Application Ref:	3/2020/0303	 Ribble Valley Borough Council www.ribblevalley.gov.uk	
Date Inspected:	11/05/2021		
Officer:	AB		
DELEGATED ITEM FILE REPORT:		Decision	APPROVED

Development Description:	Proposed external works including stone wall with timber entrance gates.
Site Address/Location:	1 Wildmans Barn Longsight Road Langho BB6 8AD

PROPOSED Plan & Elevation

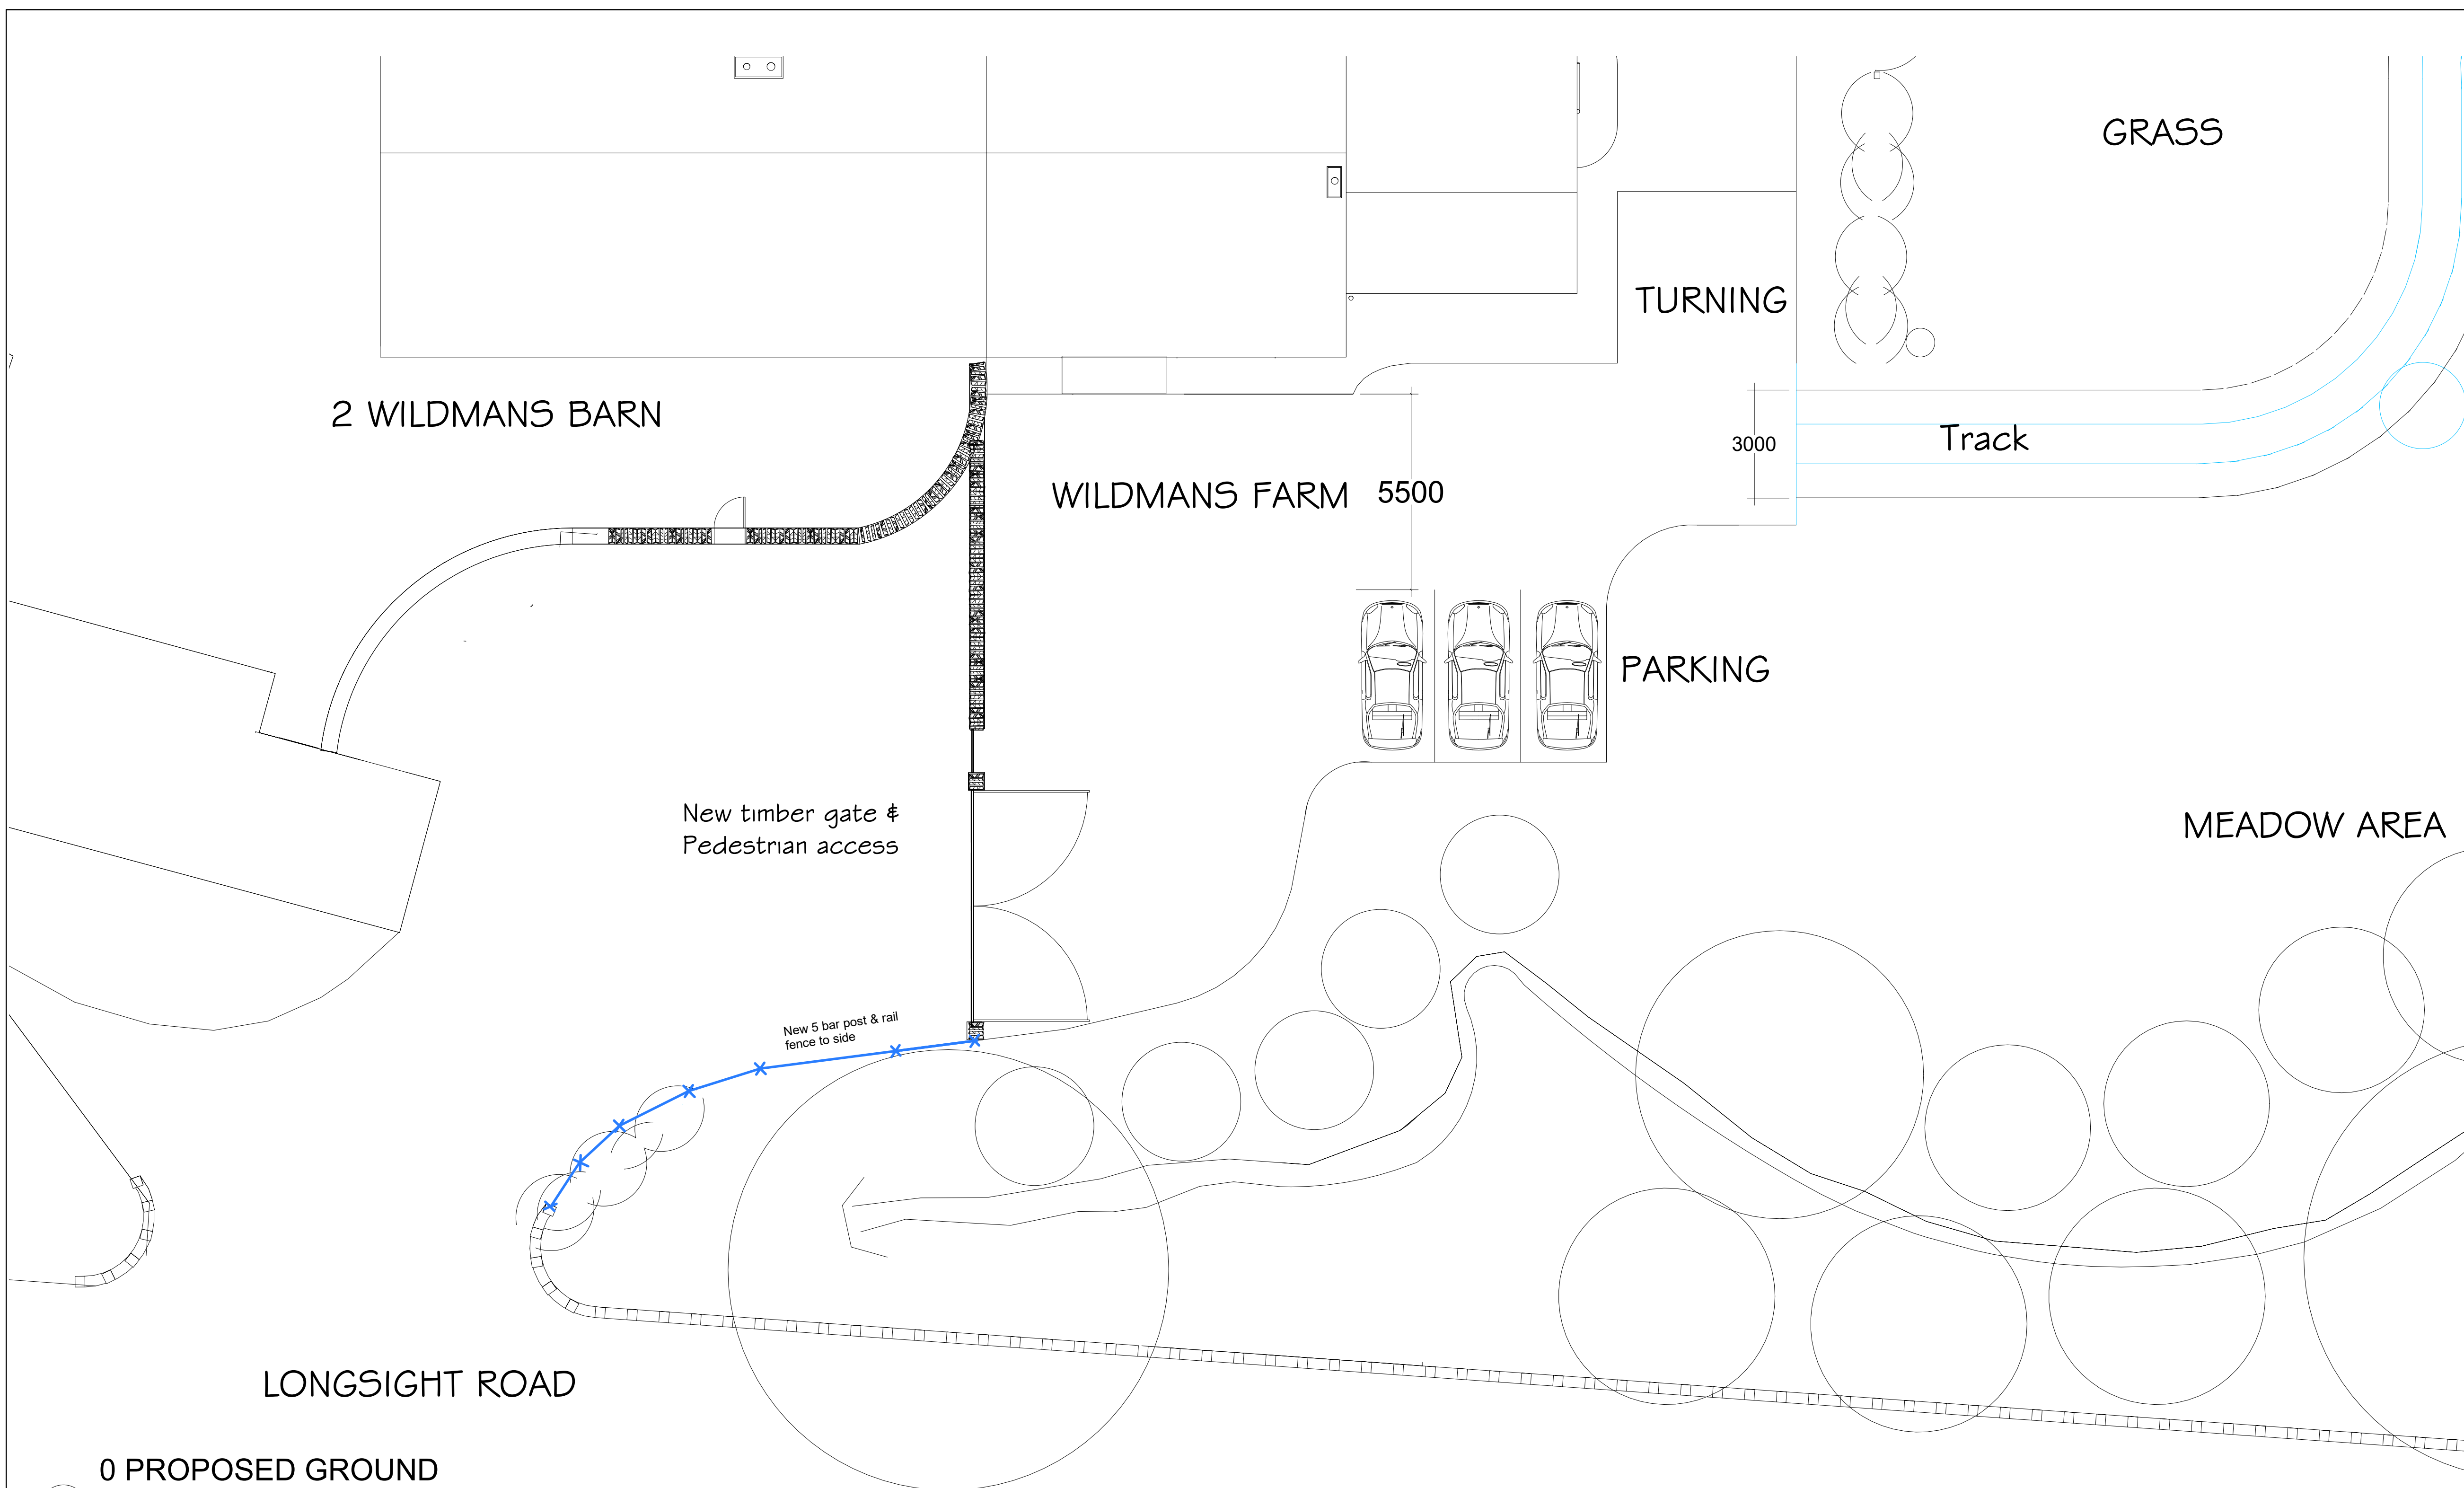
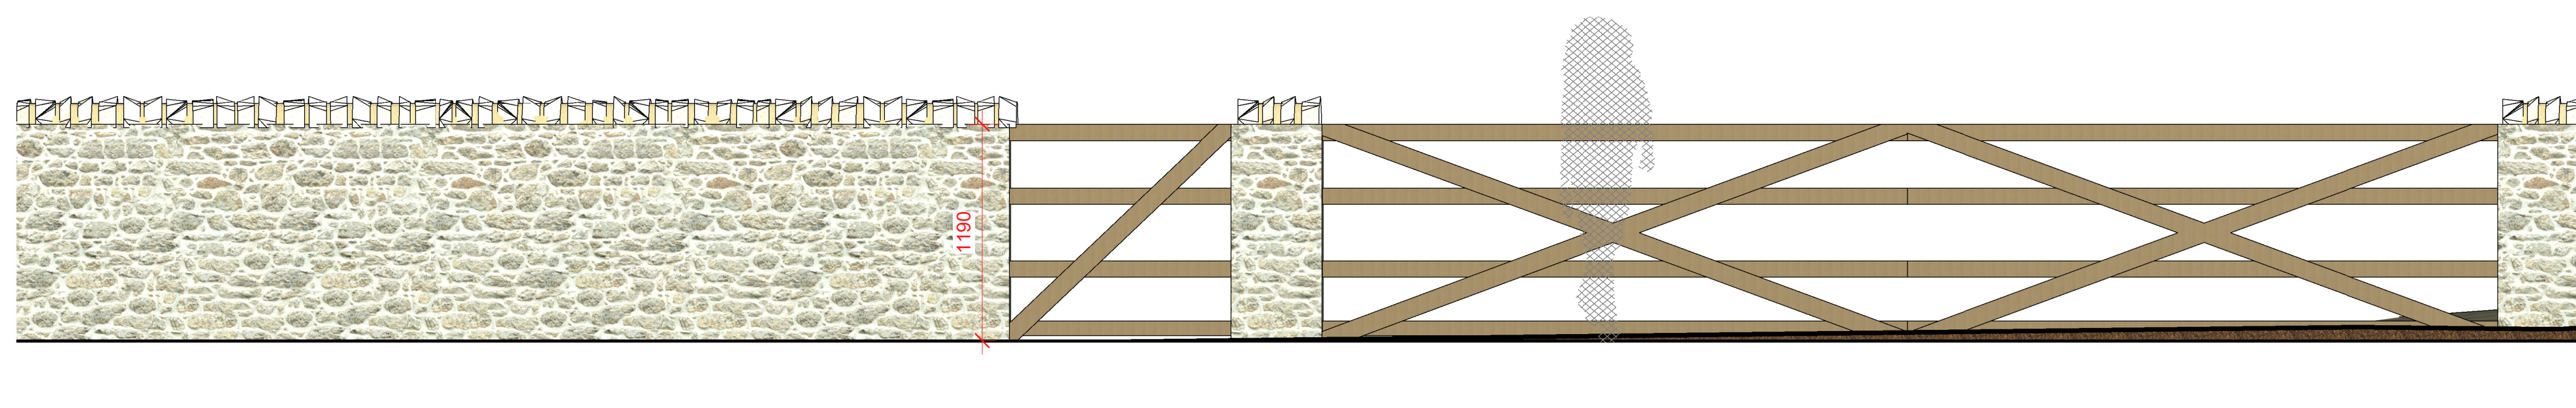
The proposed development adopts a more domestic appearance and would be somewhat at odds with the existing low boundary treatments which retain a sense of openness. The applicant has been advised that any new walling should match the height and details of existing stone walls and that new gates should not exceed the height of existing boundary treatments with a preference for a simple five-bar gate to retain the site's character. The proposals have been amended accordingly and are now considered to be acceptable and in keeping with surroundings in accordance with Core Strategy Policy DMG1.

PROPOSED Elevation

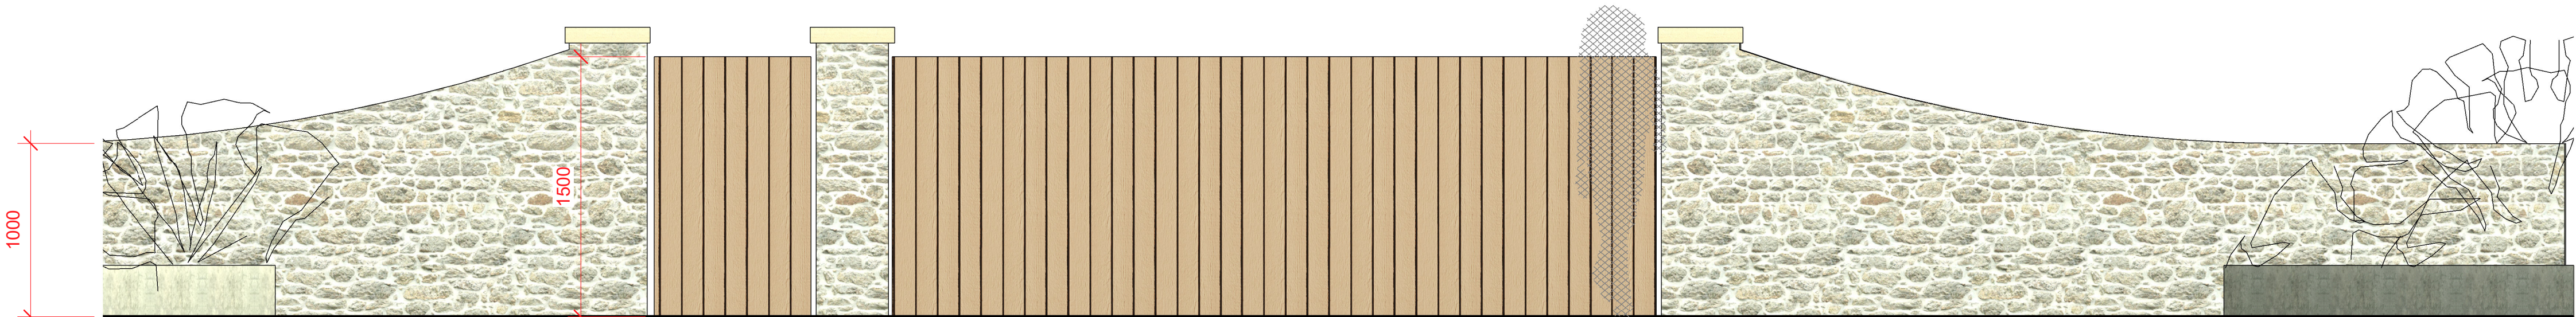
As submitted, the proposed walls would be built from random stone up to a height of 1.5 metres and topped with coping stones. Proposed gates would be 1.5m high and of solid timber construction.
